RE: Submission in response to the Dinawan Wind Farm EIS (SSD-50725708)

Origin Energy Power Limited (Origin) appreciates the opportunity to provide a submission in response to the Dinawan Wind Farm (DWF) Environmental Impact Statement (EIS) submitted by Spark Renewables Pty Limited (SSD-50725708).

As the owner of Yanco Delta Wind Farm (YDWF) which borders the DWF, Origin has carried out a review of the DWF EIS and identified a number of aspects that are inconsistent with the YDWF Project (SSD 41743746) approval, dated 21 December 2023. Notably, the DWF EIS has not included the approved YDWF project footprint, and in particular, the approved transmission connection along McLennons Bore Road/Cadell Road to the Dinawan Substation has not been appropriately identified.

PROJECT:
**DINAWAN WIND FARM
STRATEGIC CONCEPT DESIGN -
INTERSECTION
KIDMAN WAY & MCLENNONS BORE
ROAD ID101**

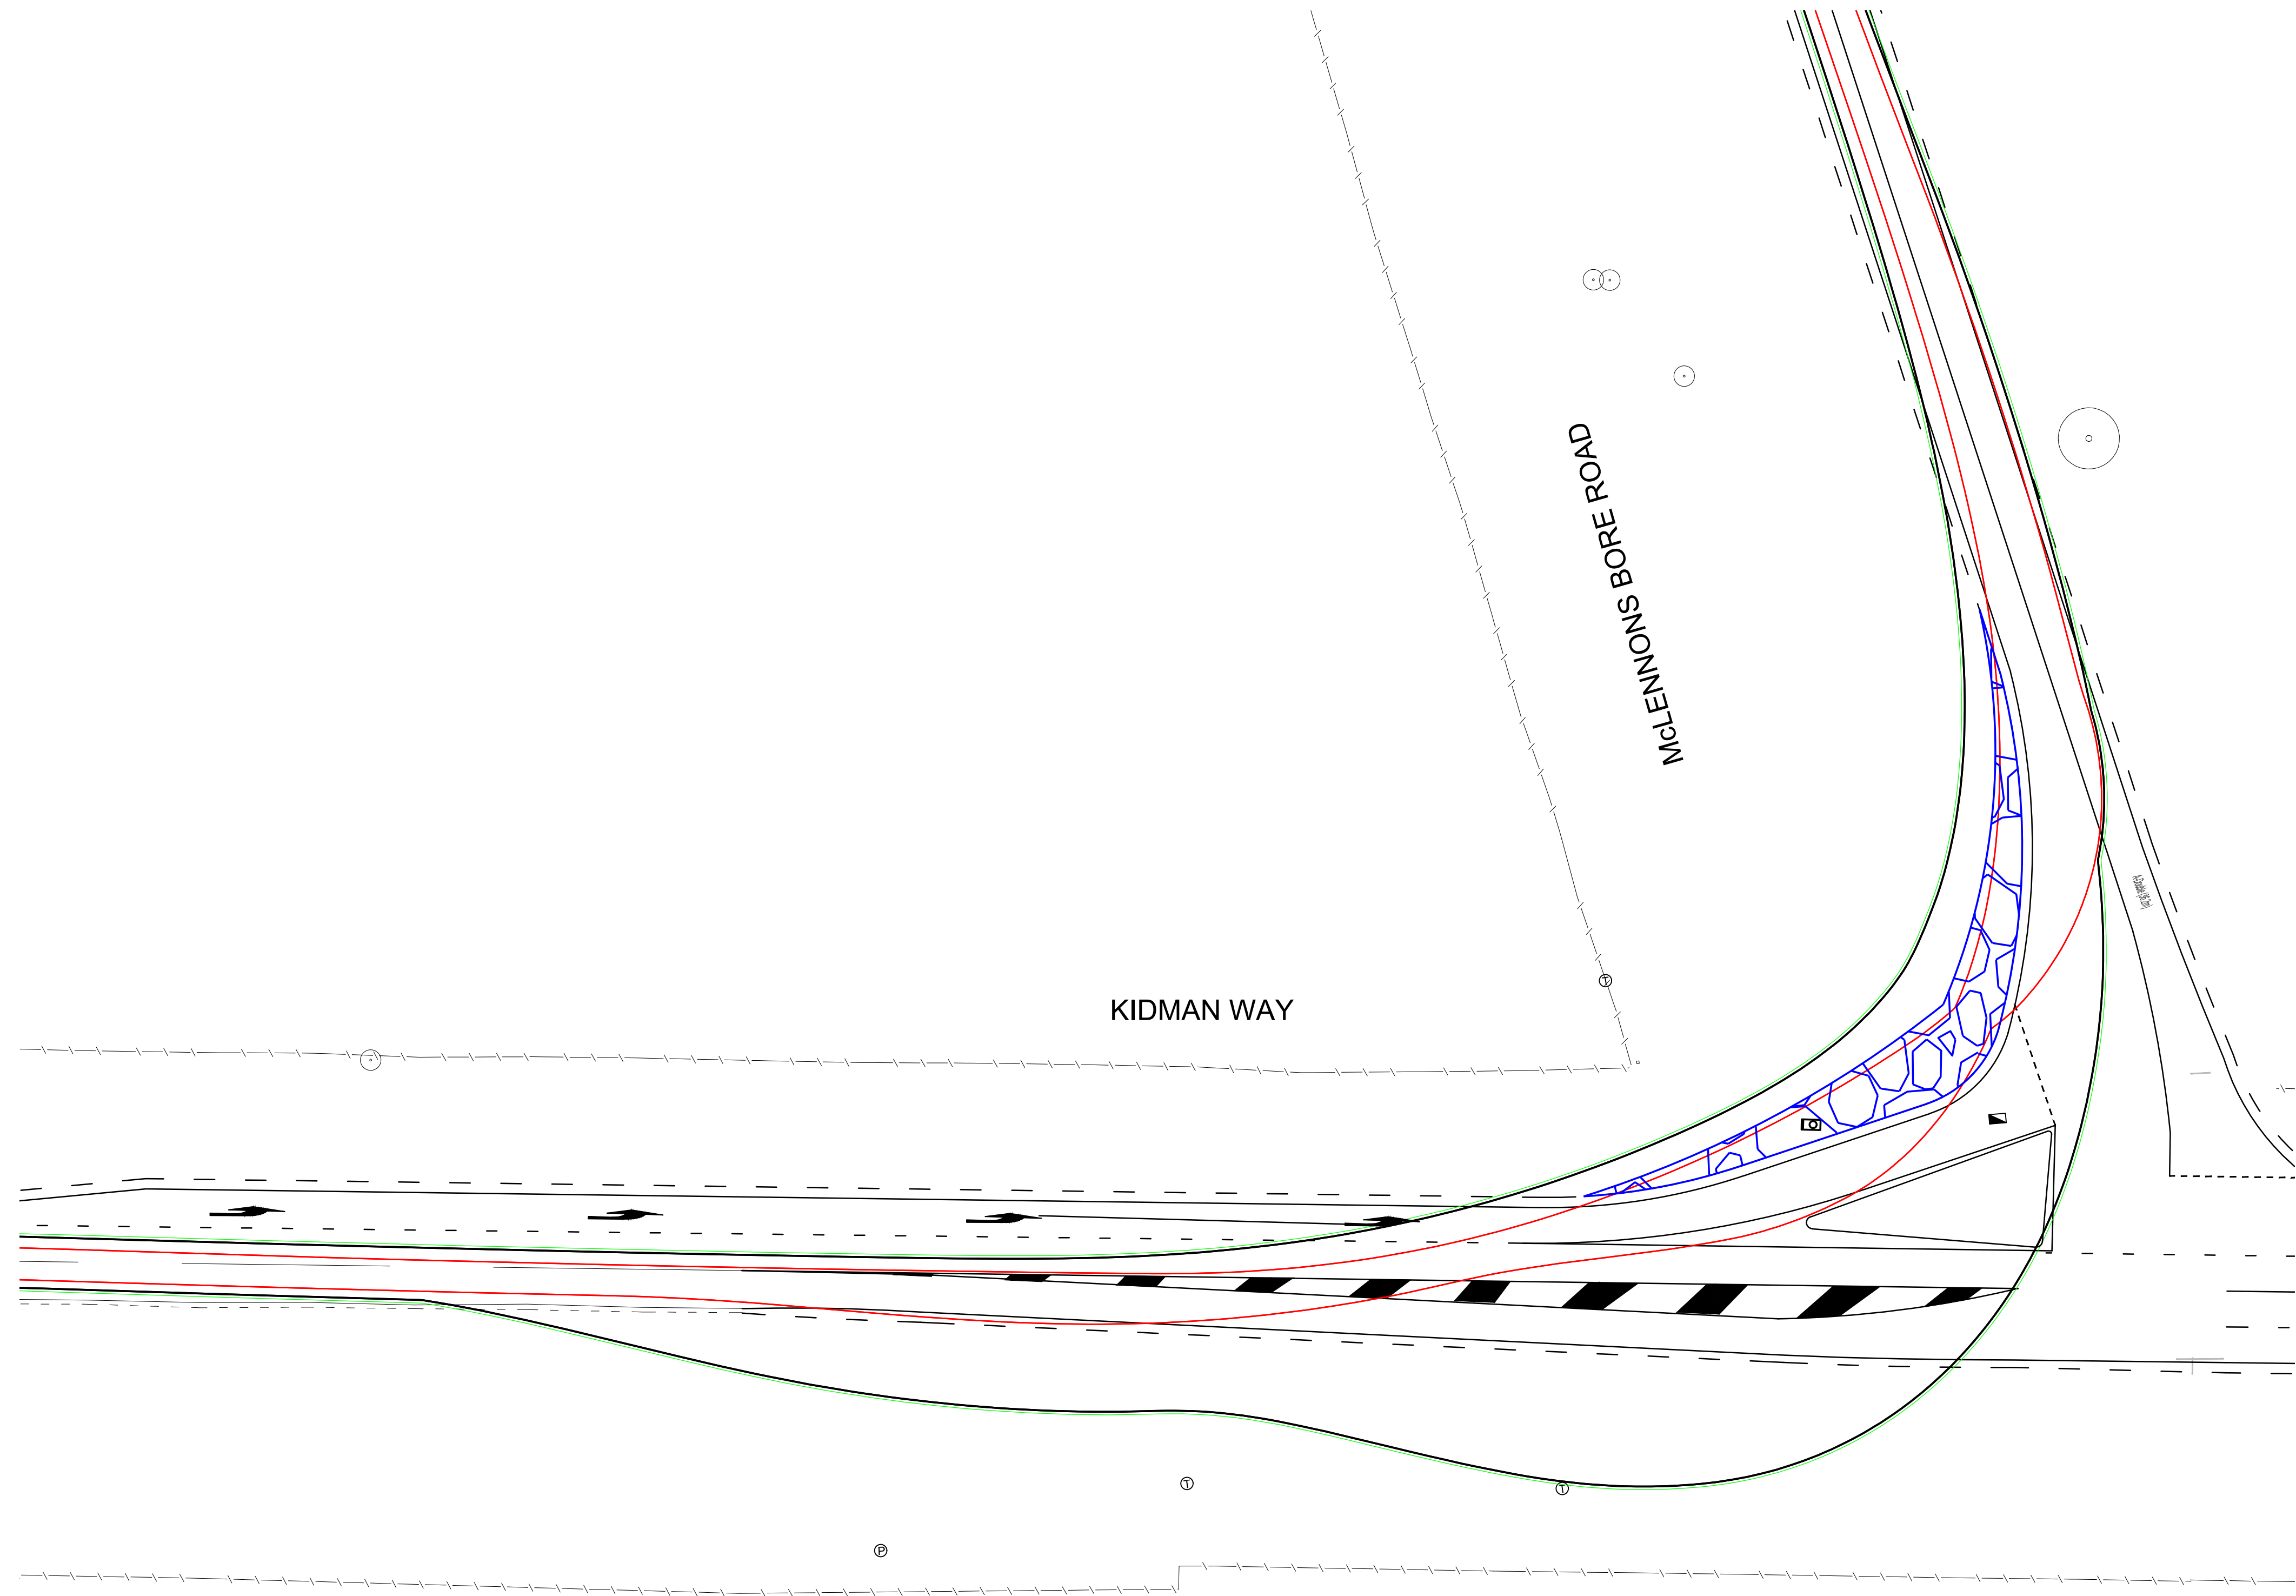
- As stated in the DWF EIS, construction of the DWF will coincide with the YDWF construction period. The DWF access points and main access route for high risk and Oversize and/or Overmass Vehicles (OSOM) has not taken into consideration the construction and/or operation of the proposed transmission line along McLennons Bore Road.
